**WEST SUSSEX COUNTY COUNCIL
STRATEGIC PLANNING CONSULTATION**

DATE: 13th January 2017

SUBJECT: P/76/16/PL - Construction of a building for the packaging, preparation & distribution of fresh foods with ancillary accommodation associated with the existing horticultural business, revisions to internal access road, car parking & hardstanding areas & landscaping & provision of a wetland. This application affects the setting of Listed Buildings.

LOCATION: Sefter Farm, Pagham Road, Bognor Regis, West Sussex, PO21 3PX.

SCALE: 1:1000

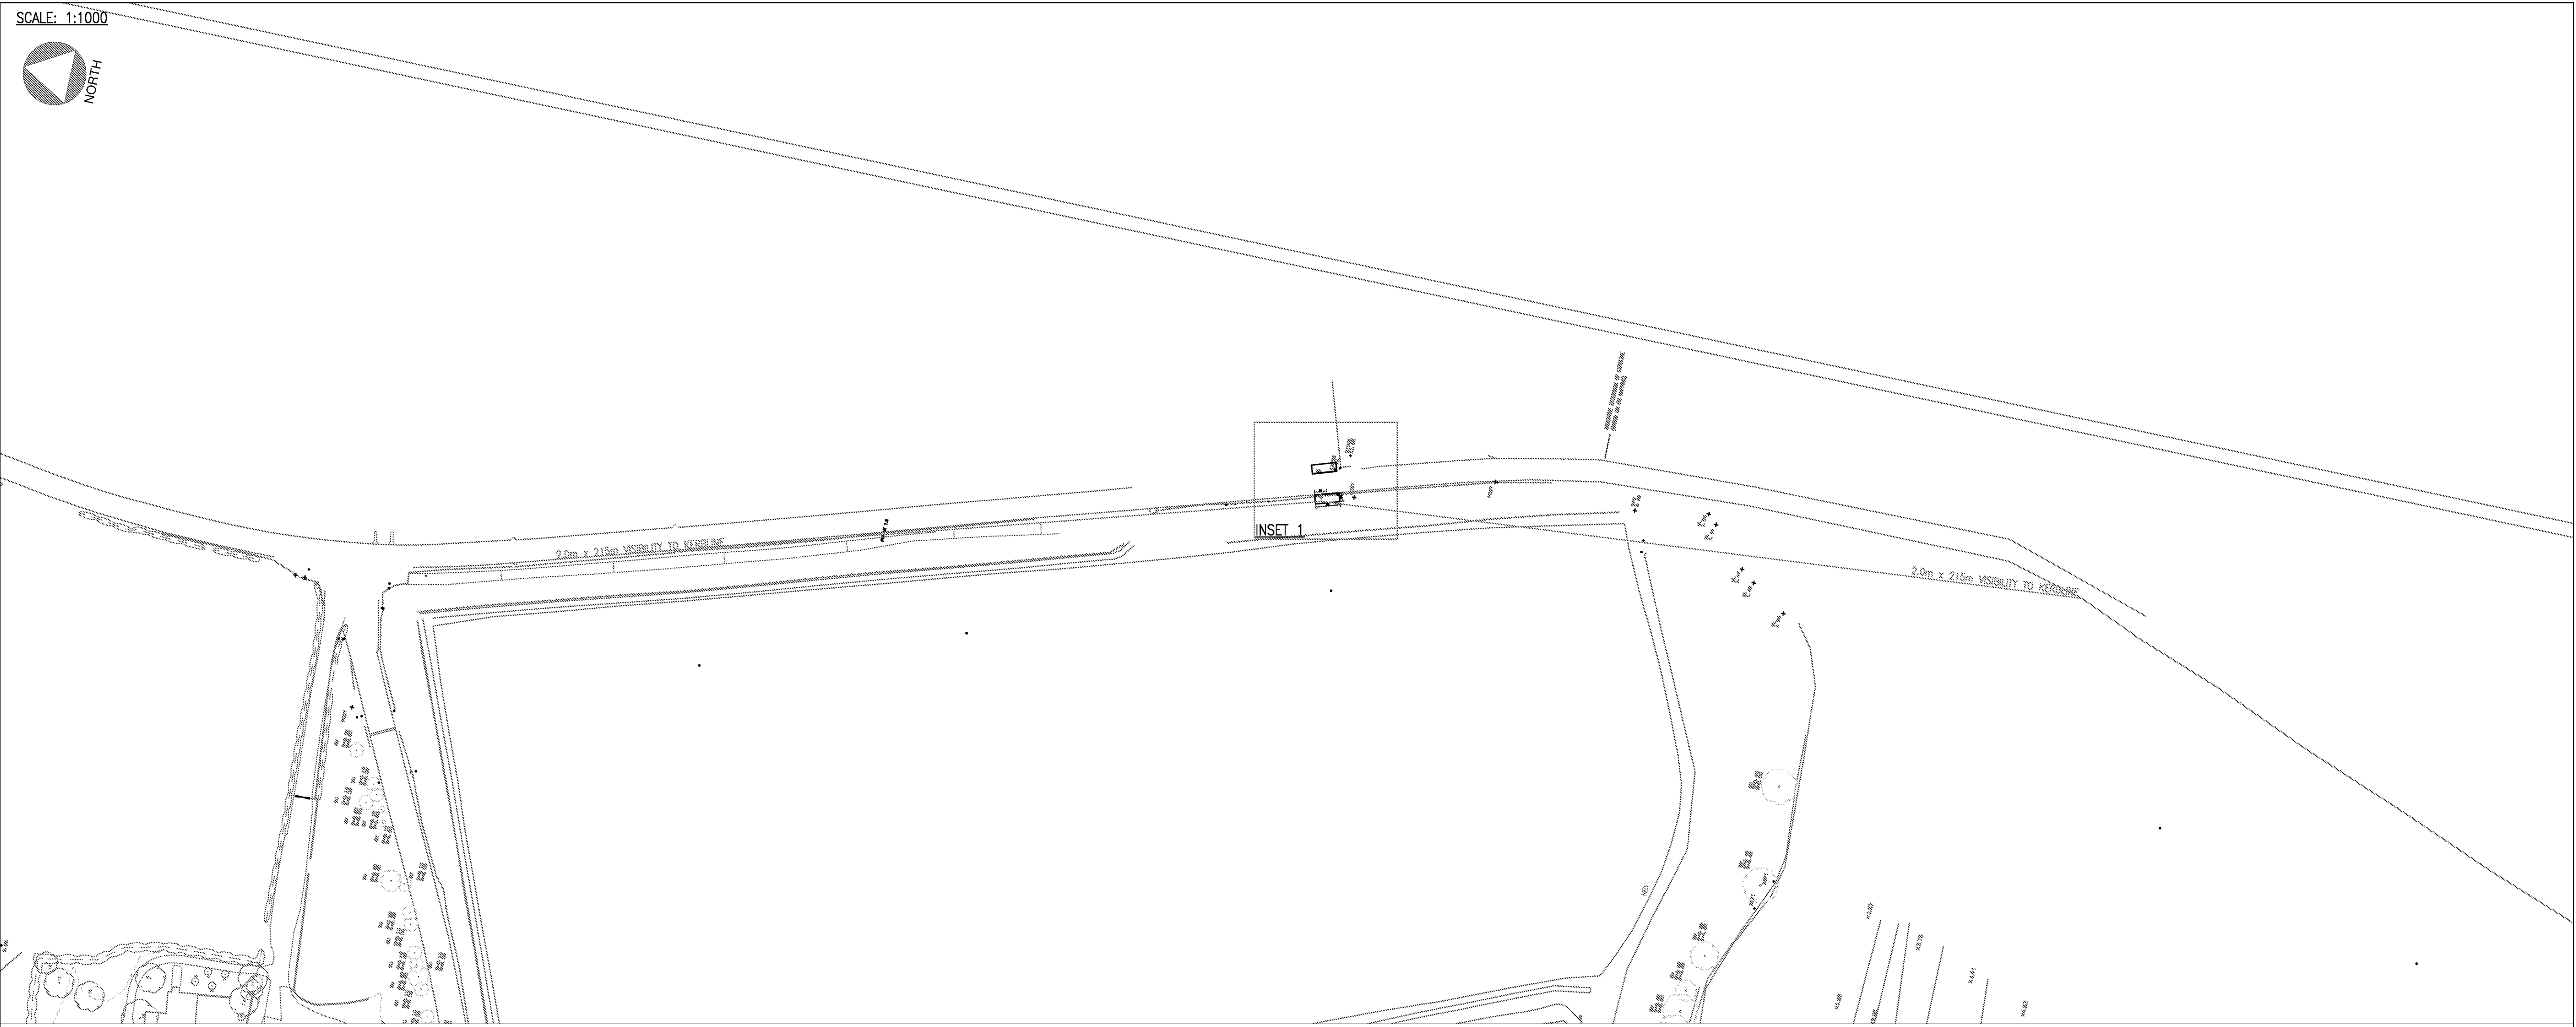
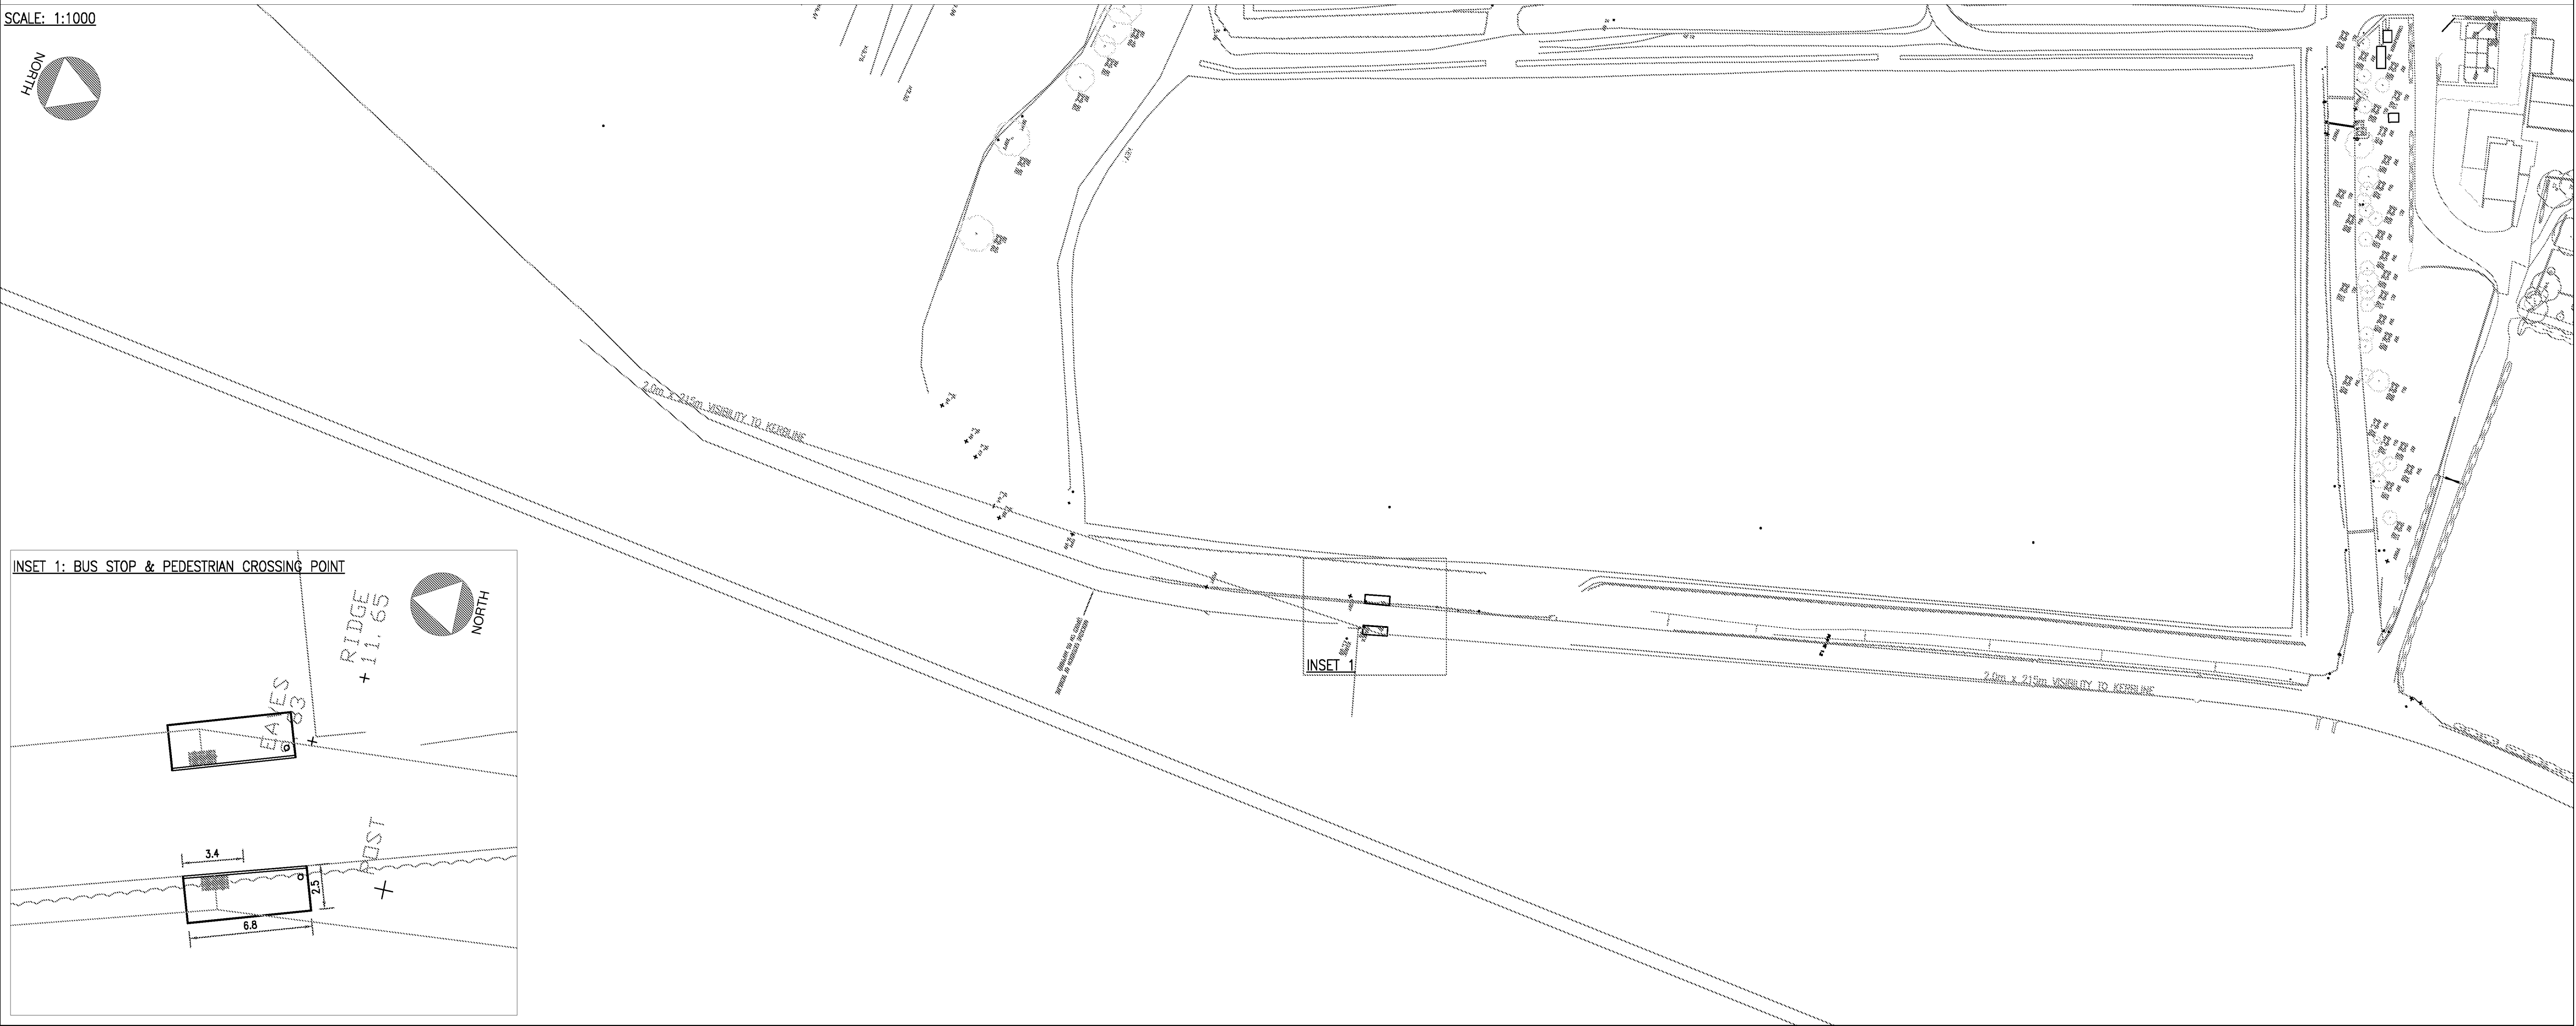
Taking the first statement; Although vehicular access in and out of the site is via the E-W private access road, both the CHA and independent Road Safety Audit recommend that it be improved with regard to visibility at the point it joins Pagham Road. Therefore, to say it will be as *existing* is not correct.

Accesses (vehicular and pedestrian) - Turning to suitability of the access and road safety considerations thereof, The CHA, Road Safety Report and now the recently submitted Road Safety Audit all identify shortcomings with the entrance and the nearby pedestrian access to the site.

Therefore, in an attempt to conclude the matters raised in the Road Safety Audit (RSA), the applicant should review their response made in the Designer's Response (DR) to the RSA and provide clear plans showing appropriate visibility improvements to both the vehicular and pedestrian access points as recommended in the RSA in order to accommodate the additional vehicular impact. At that stage, the CHA will review these and comment on whether they are suitable. For avoidance of doubt, the plans (CEP or PBA) do not show what is required.
